ENG-CDR23021-R2-CDs-S2.pdf Markup Summary

1.000	ROUNDABOUT GRADING & STRIPING
1.050	STRIPING PLAN
1.100	POWER PLANS
1.150	STORMWATER DETAILS
1.200	DETAILS

STORM-07 (PUBLIC)

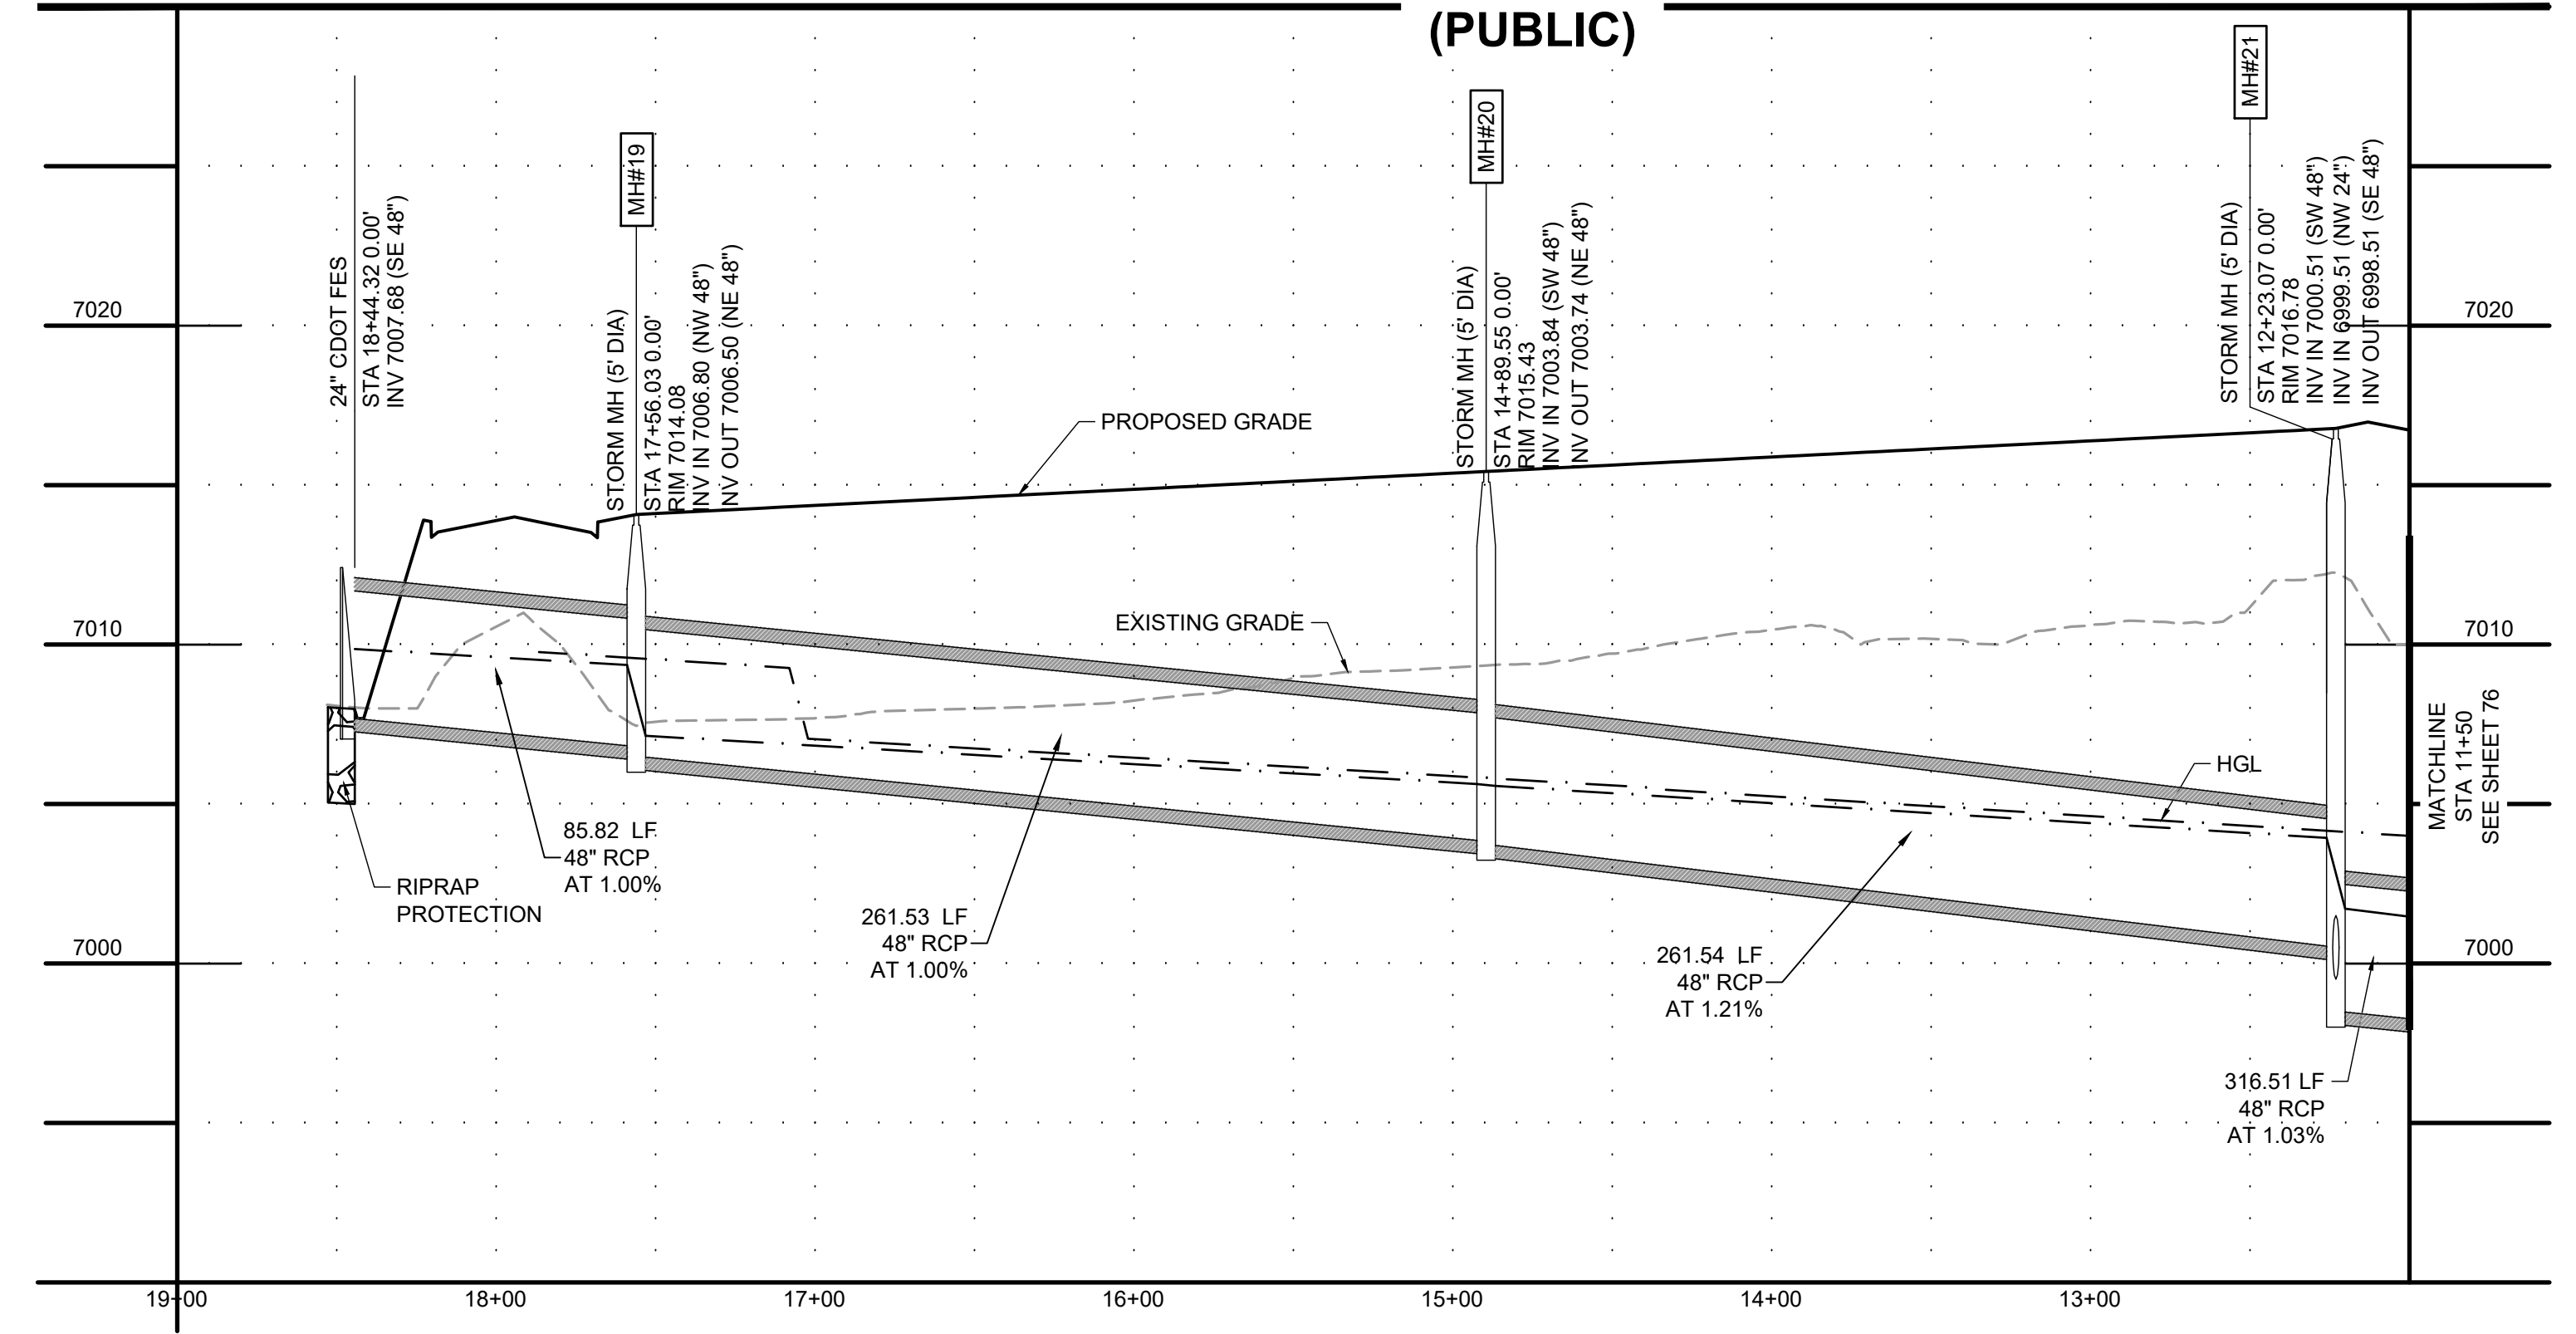
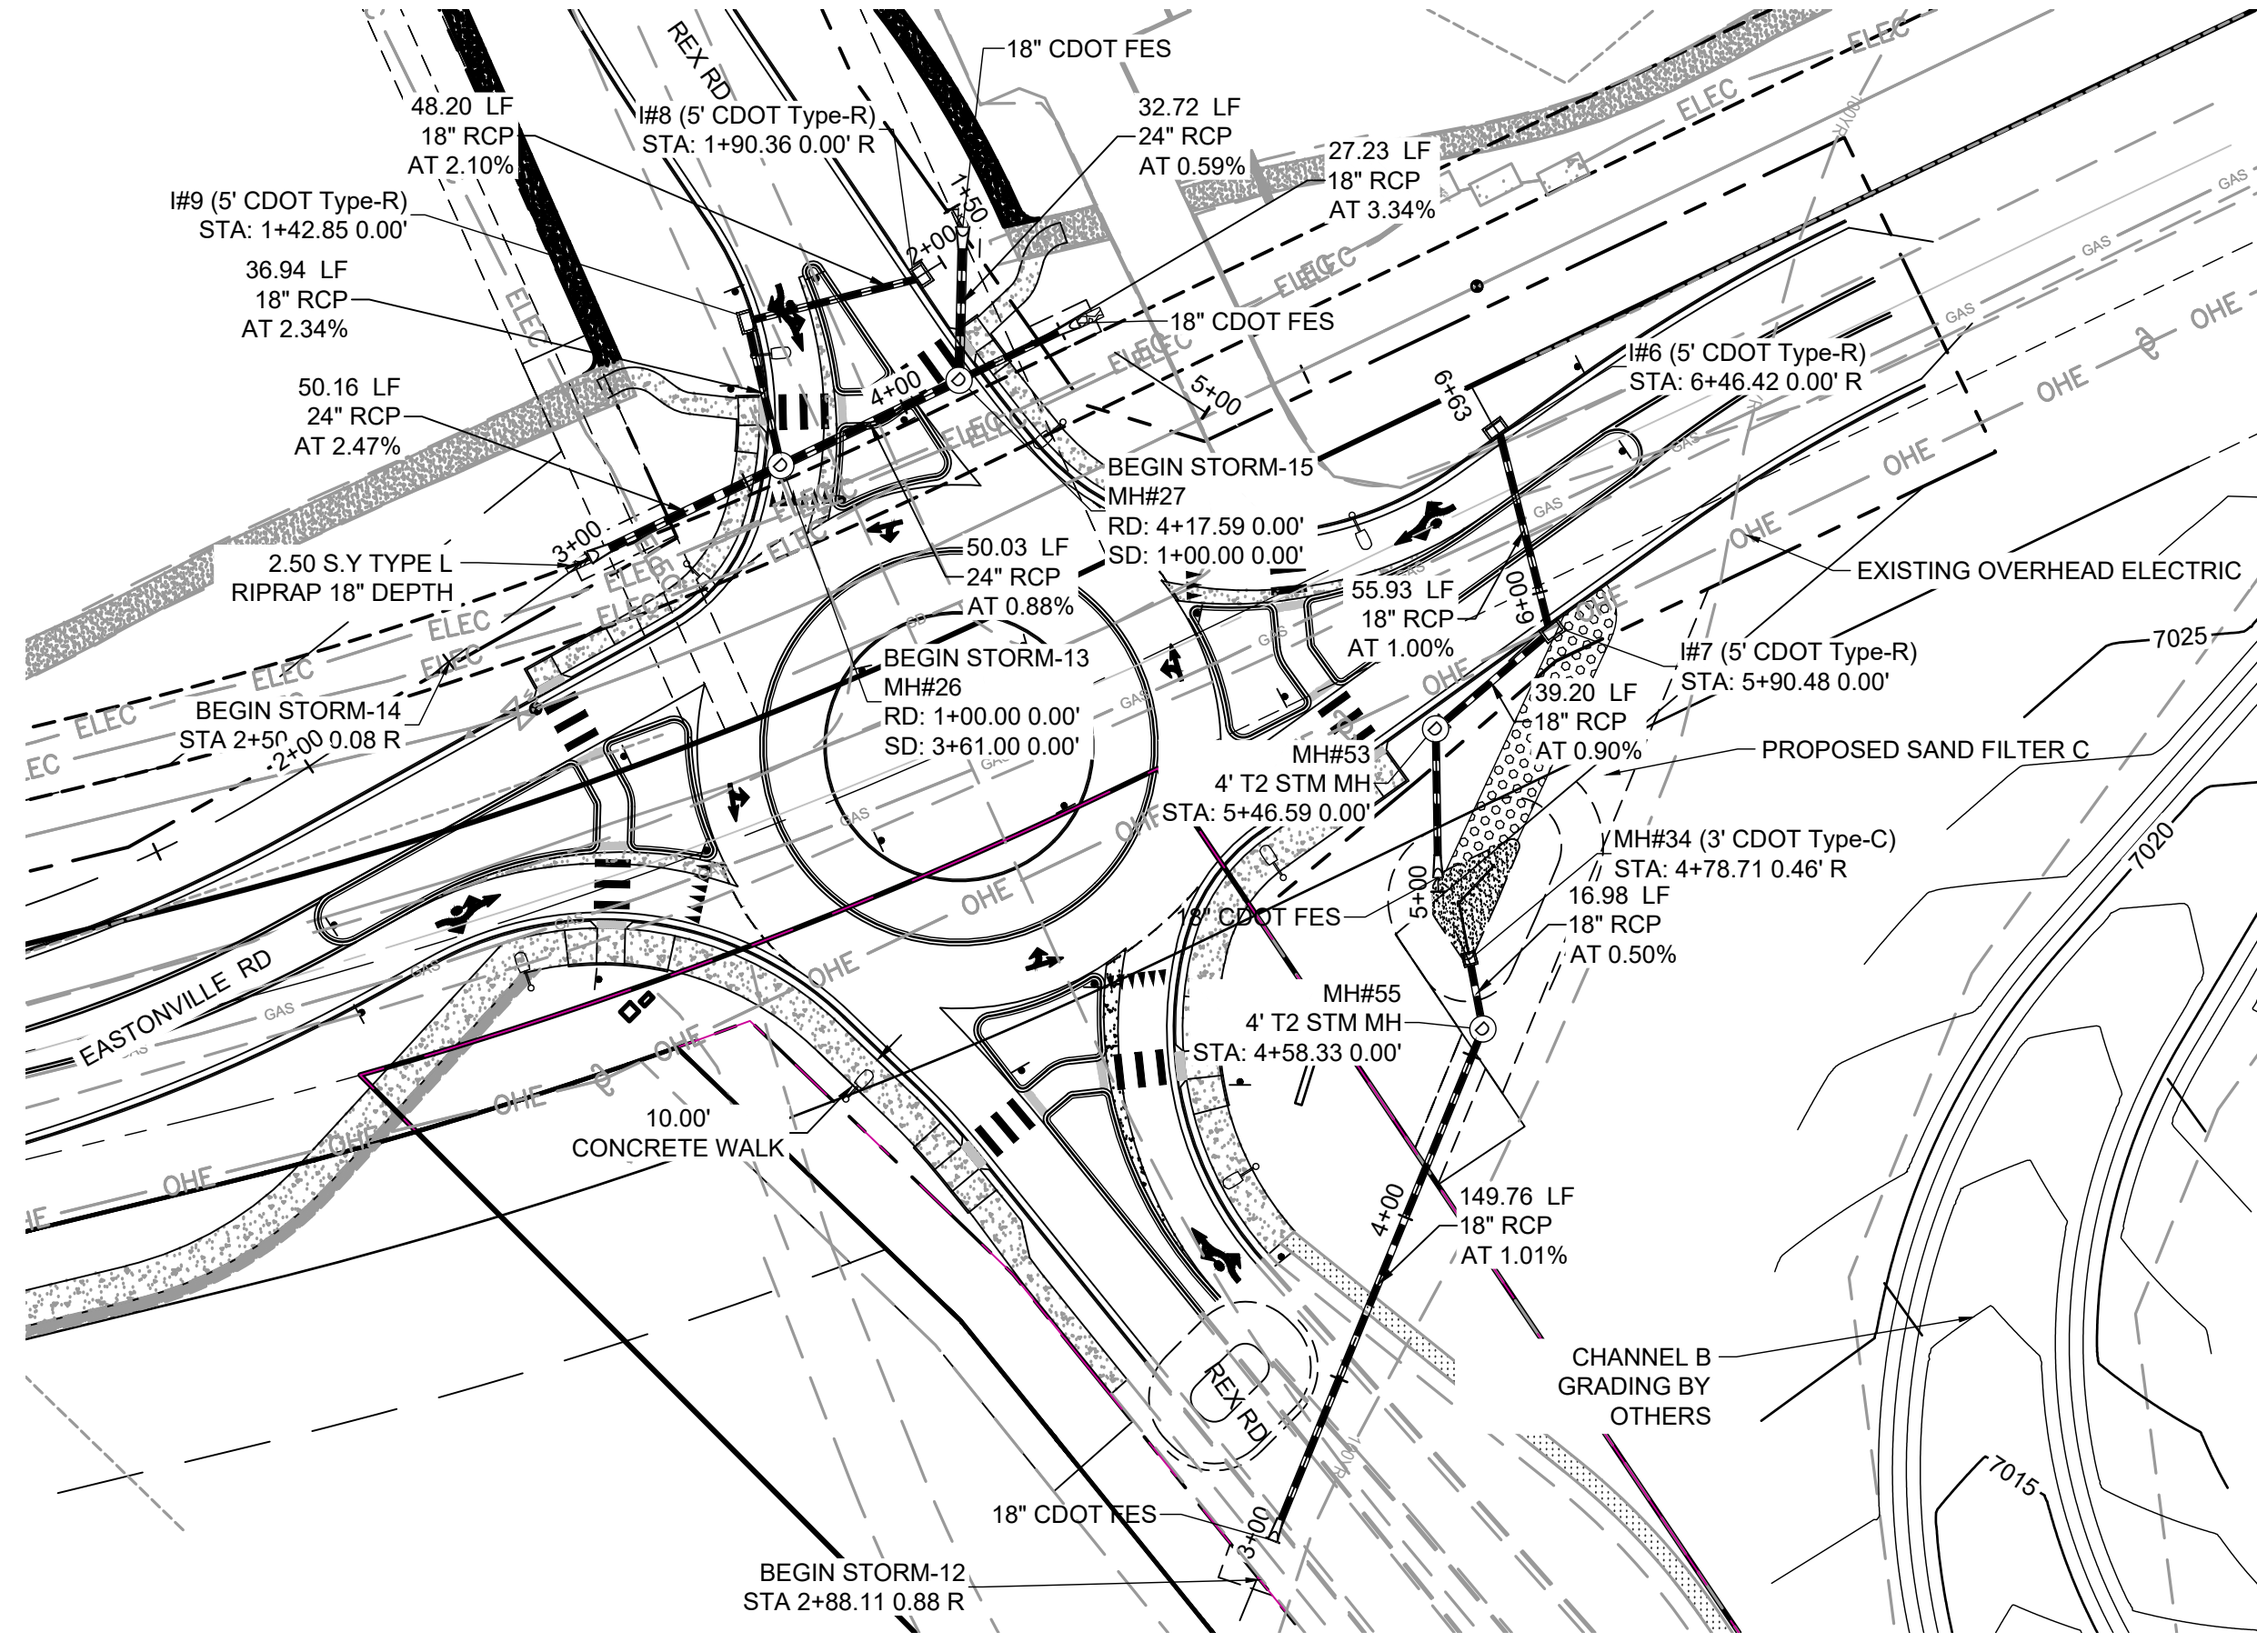
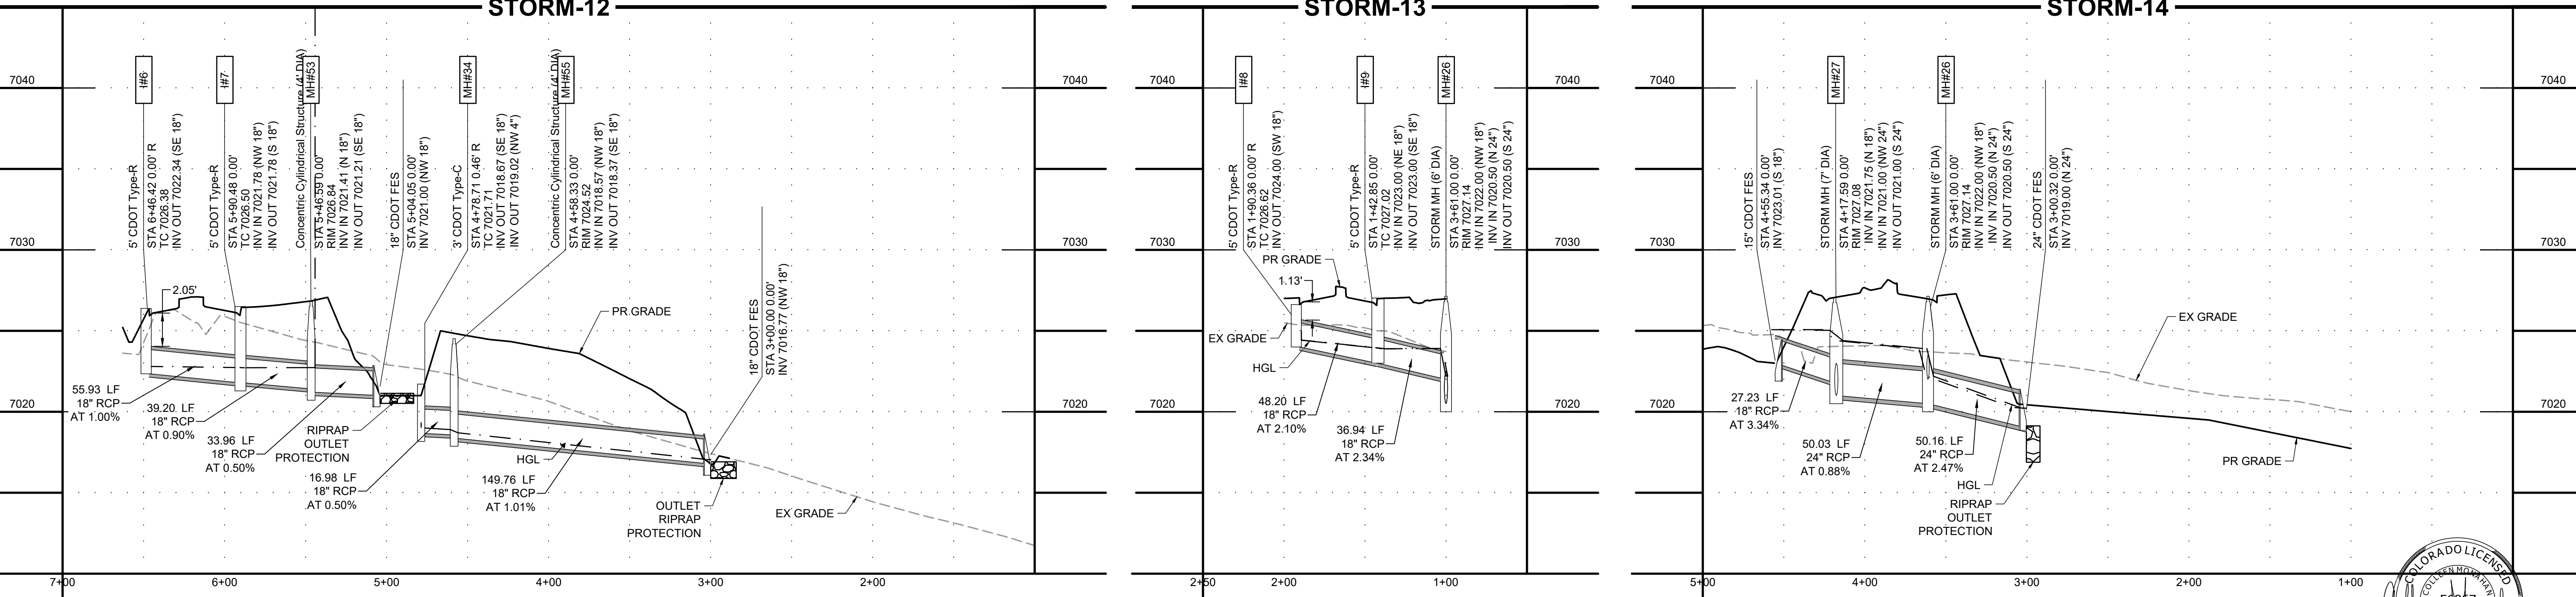
Subject: Callout
Page Index: 25
Date: 4/10/2024 12:46:40 PM
Author: Jeff Rice - EPC Engineering Review
Color: ■
Layer:
Space:
Page Label: [25] 57 STORM PLAN & PROFILE

locking lid?
